**re: Geotechnical Review of Grading Plan
Proposed Commercial Development**
801 Eagleson Road – Ottawa, Ontario

date: July 29, 2025

file: PG2574-MEMO.04

GRADING PLAN

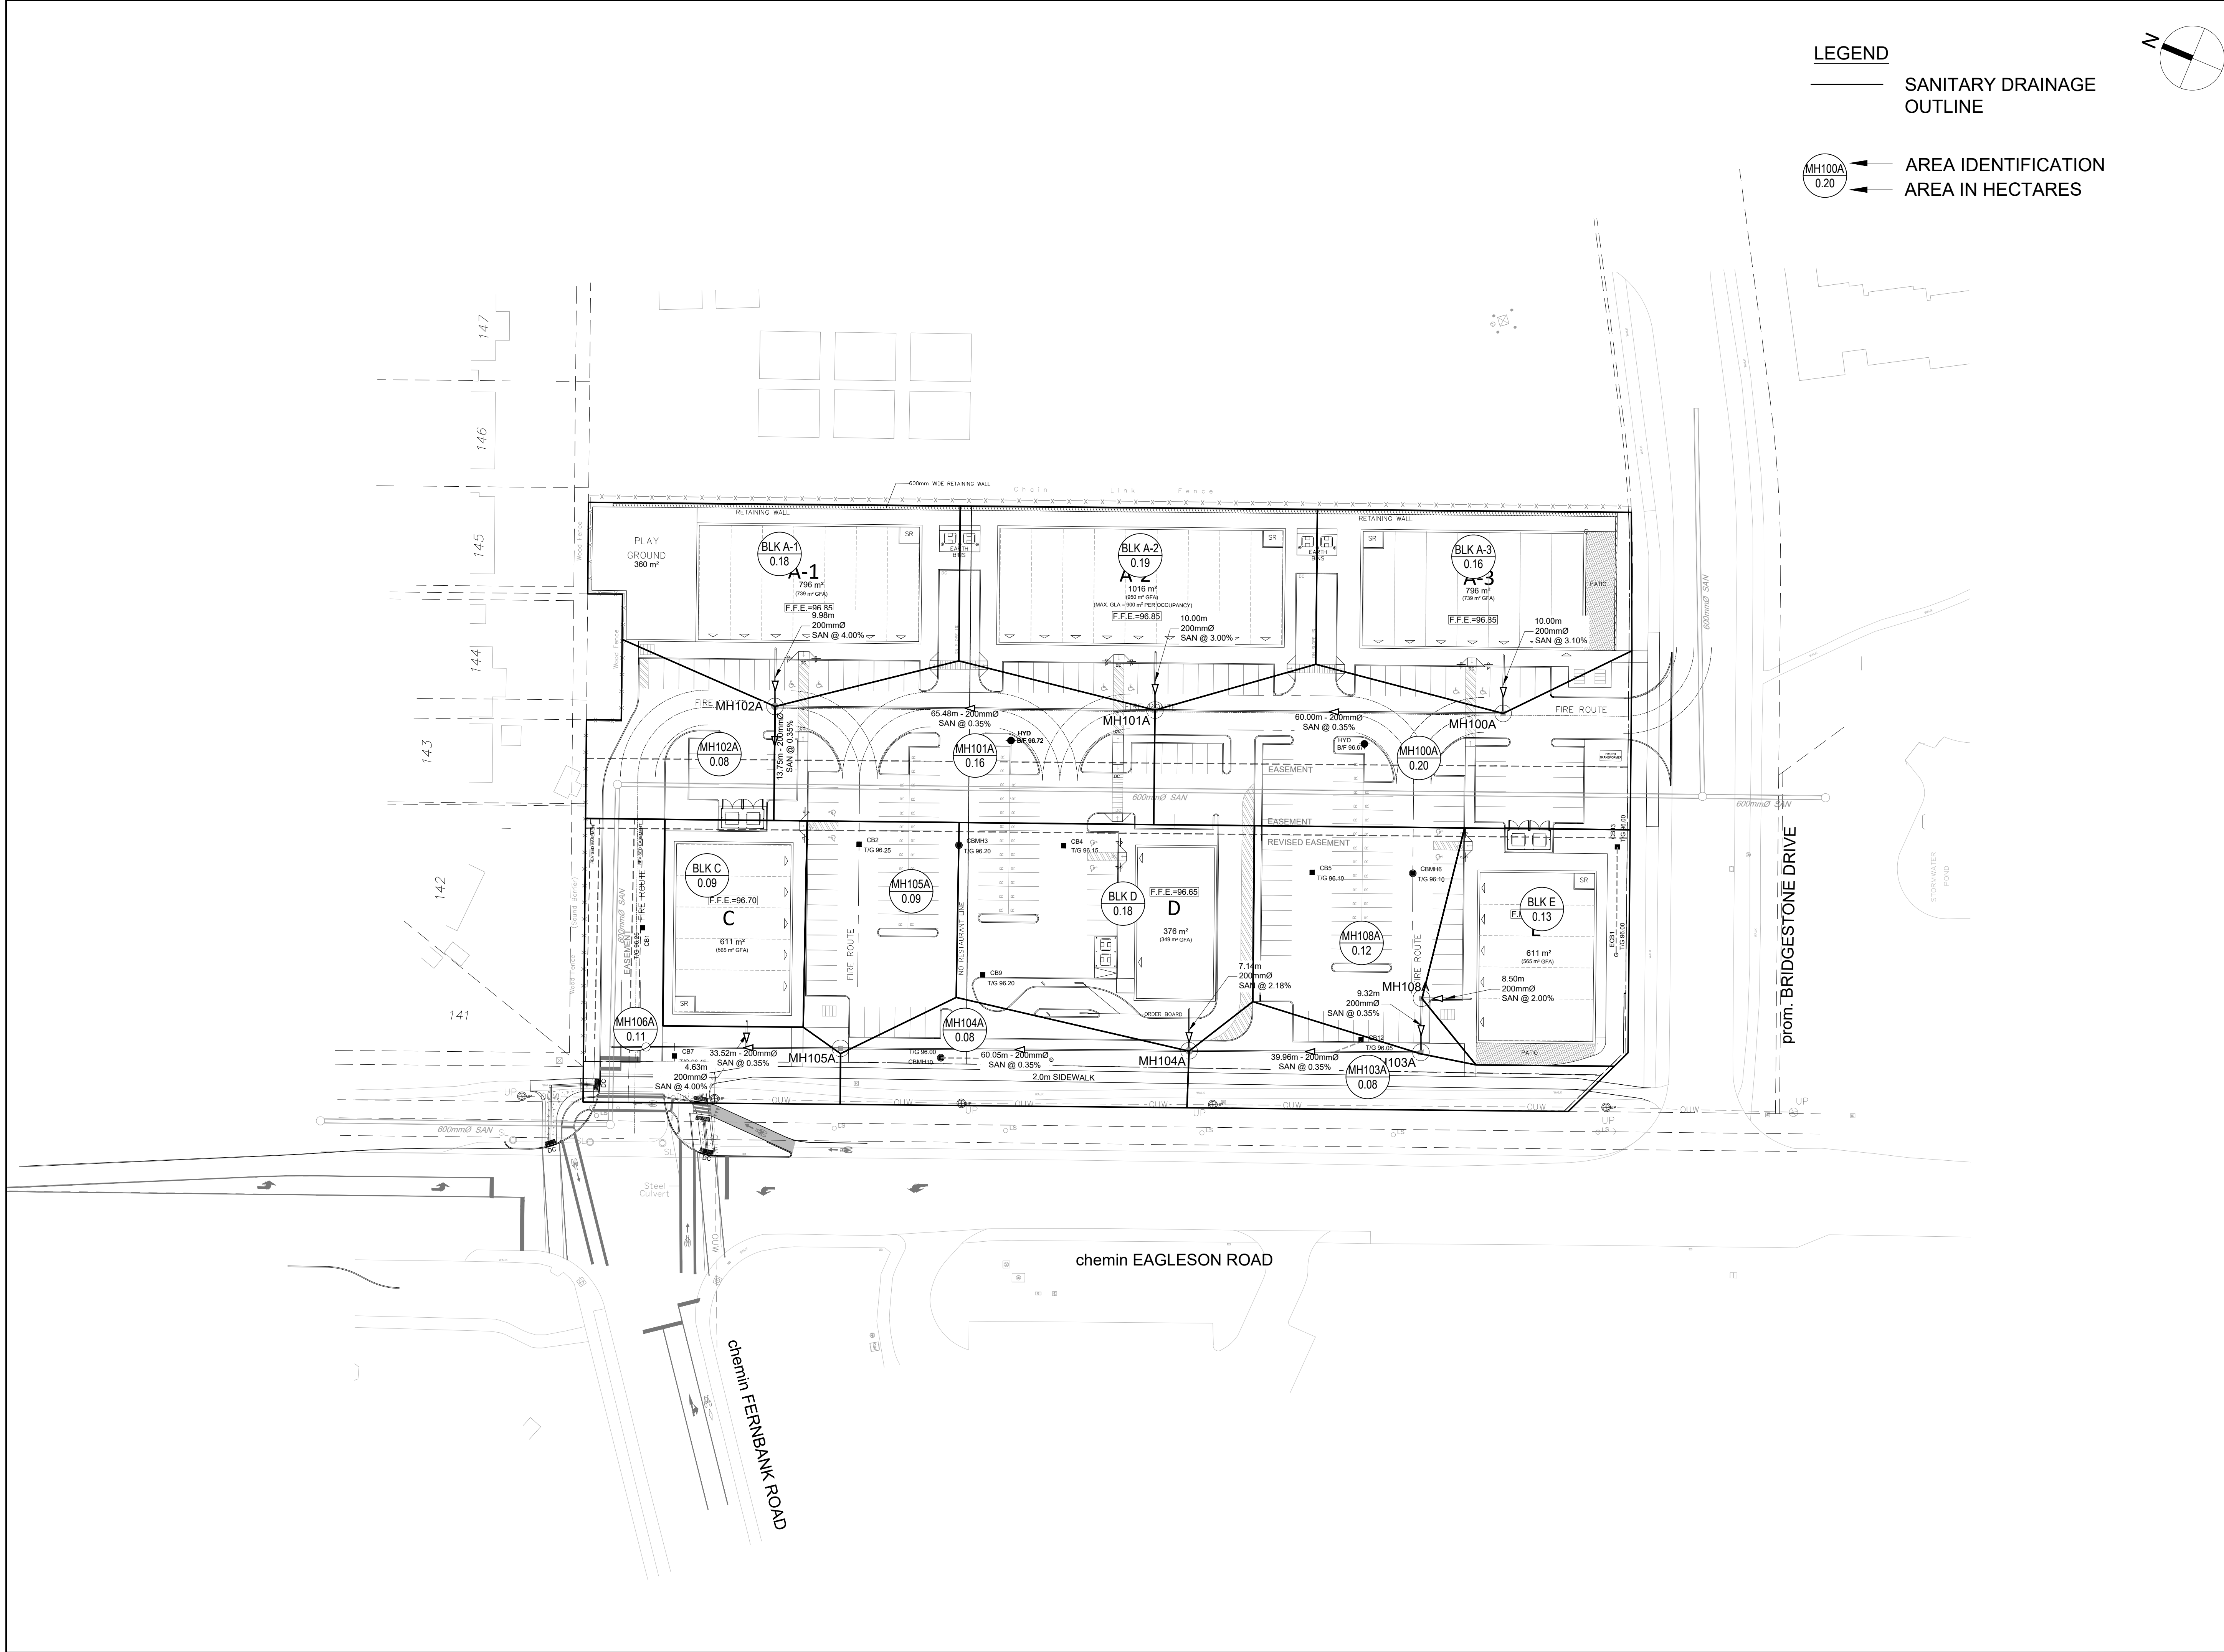
Due to the presence of a silty clay deposit at the site, the development is subject to grade raise restrictions. As noted in Section 5.3 of the above-mentioned geotechnical report, a permissible grade raise restriction of **96.7 m** (geodetic) is recommended for finished grading within 6 m of building footprints, and a permissible grade raise restriction of **97.7 m** (geodetic) is recommended for car parking areas and access lanes beyond 6 m of building footprints.

Based on our review, the proposed grading for the subject site is generally within the permissible grade raise recommendations provided in the geotechnical report with the exception of portions of Buildings A-1 to A-3, within the northern half of the property. Where localized grade raise exceedances are proposed, placement of lightweight fill (LWF), such as expanded polystyrene (EPS) geofoam blocks, is recommended below the floor slab and for areas adjacent to the subject commercial buildings. Reference should be made to Figure 2 – Markups for Lightweight Fill Placement, attached to this memorandum, for the recommended thicknesses and extents of LWF for the subject buildings.

Reference should be made to Figure 1 – Typical EPS Block Installation for Slab-on-Grade Buildings, attached to this memorandum, for a general detail depicting the recommended LWF placement. The EPS blocks should be placed on a level, well-prepared subgrade, with a geotextile separation layer to prevent soil intrusion and to promote drainage. The EPS blocks should be installed in a staggered, interlocking pattern and should be protected with a granular cover layer. The LWF placement should be conducted under the supervision of a geotechnical engineer.
